92 Farnham St.

**CITY OF PORTLAND, MAINE
DEVELOPMENT REVIEW APPLICATION
PLANNING DEPARTMENT PROCESSING FORM
DRC Copy**

2001-0268
Application I. D. Number
09/25/2001
Application Date
92 Farnham Street
Project Name/Description

RE: 92 Farnham Street - 310-F-023 - R-3 Zone

Proposed dwelling 92 Farnham St.
Owner - Alfred J. Waxler
Builder - Alfred J. Waxler
Plan maker - Alfred J. Waxler
Property lines based
on plan drawn by
BHM - Thomas Milligan, Jr.
Registered Land Surveyor
65' Scale: 1" = 12.5'

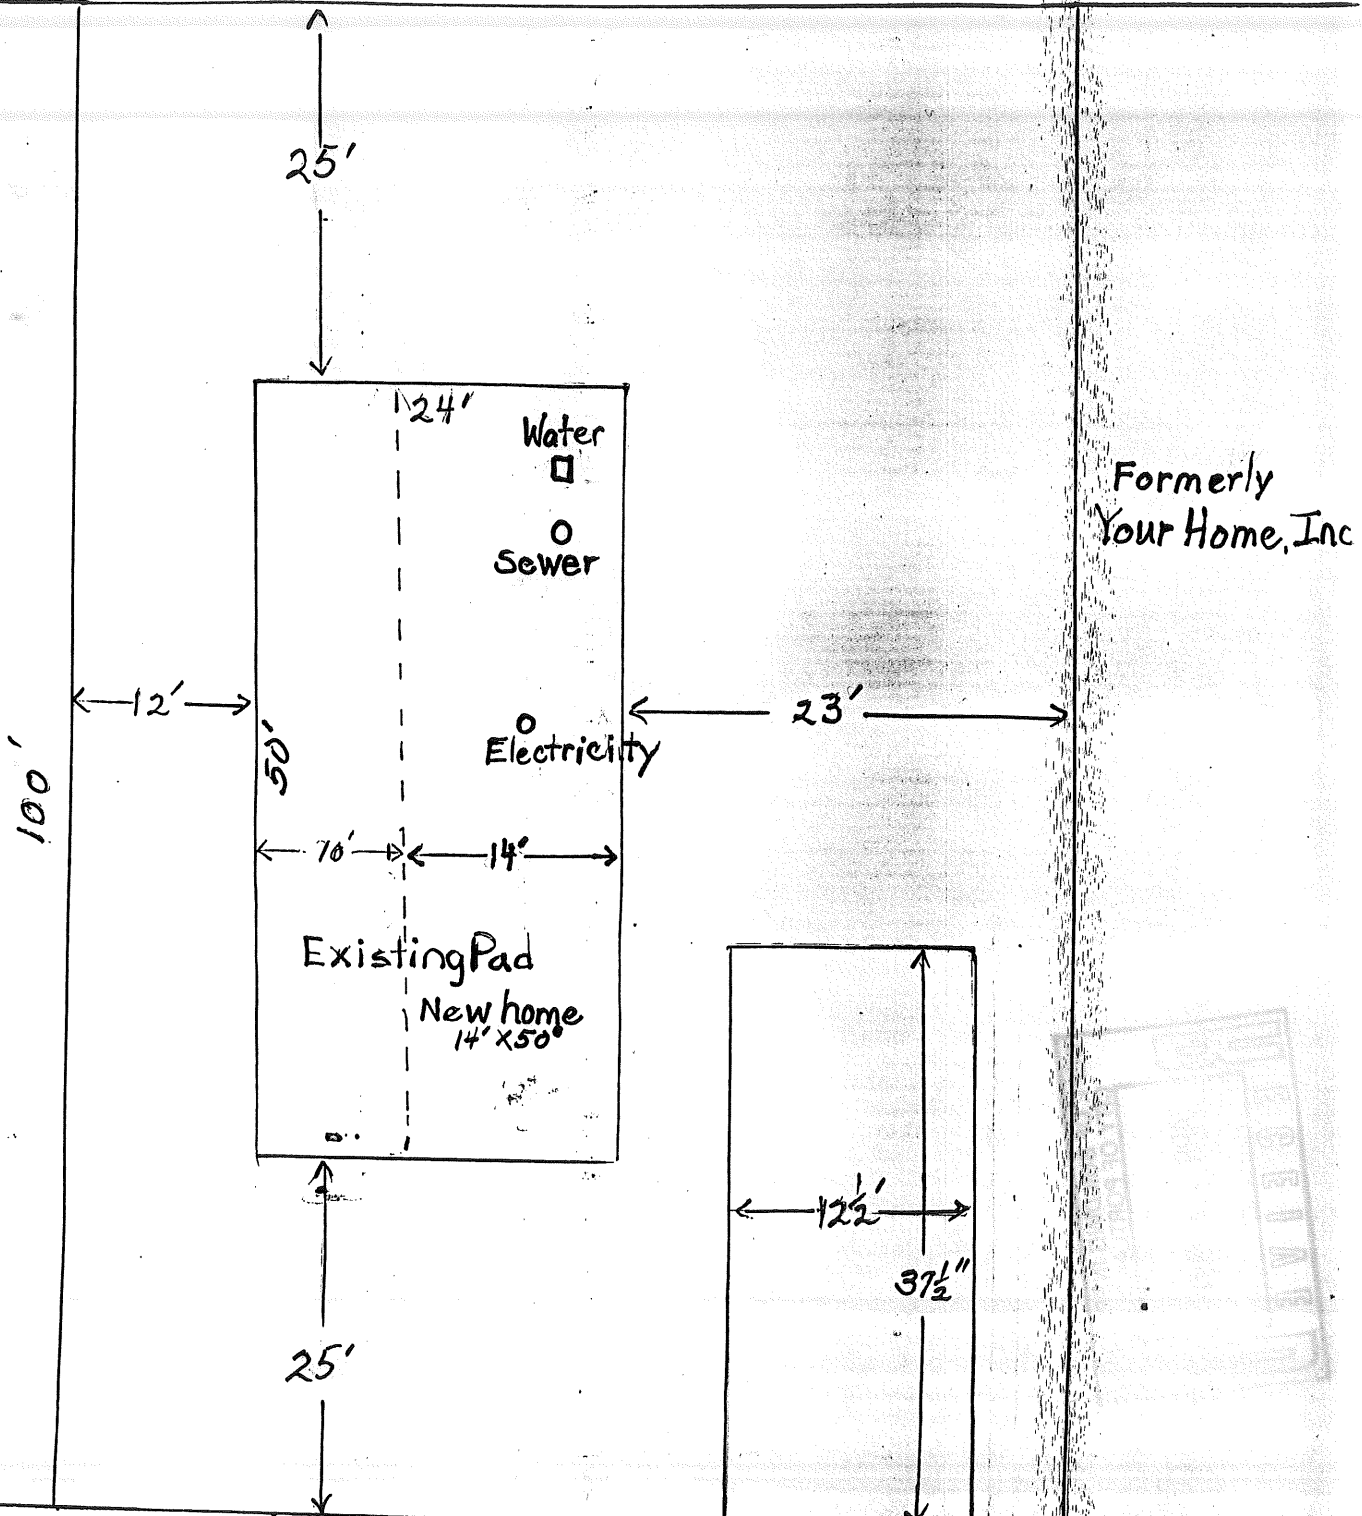
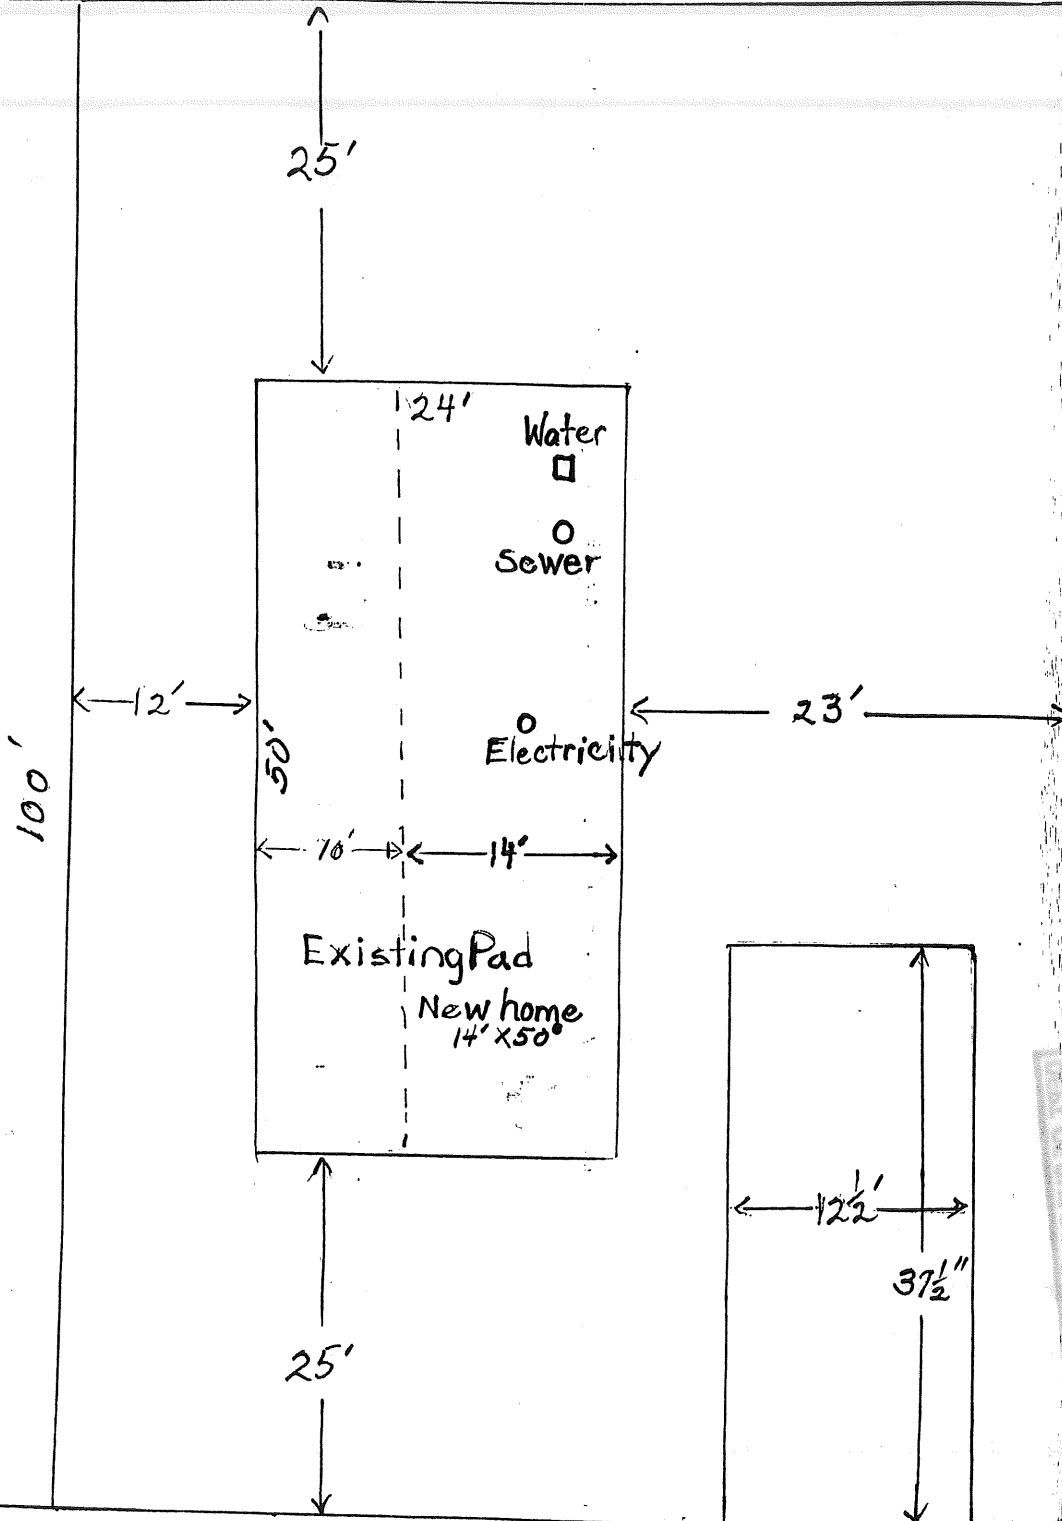
Your submitted plot plan is not complete. It does not show the entire lot with all setbacks, including the side yard setbacks. The footprint of the plot plan structure on your submitted plans is scaled out as 14' x 53'. Your application requests a permit for 24' x 50' structure. Your plot plan MUST reflect what you are actually requesting. We shall need a revised and complete site plan showing exactly what size of structure you would like to place there, and the exact setbacks from front, rear, and sides of your property. Any projections such as stairs, decks, or bulkhead shall be present on your site plan submittal. Our application form explains in detail all these requirements for a submittal for a new house. The City's Development Review Coordinator also requests further information on the site plan. Please check with him on those specifics.

Your permit is also being denied because your submittal states that your front setback from your front property line will be 21.88 feet instead of the 25 feet required under section 14-90.
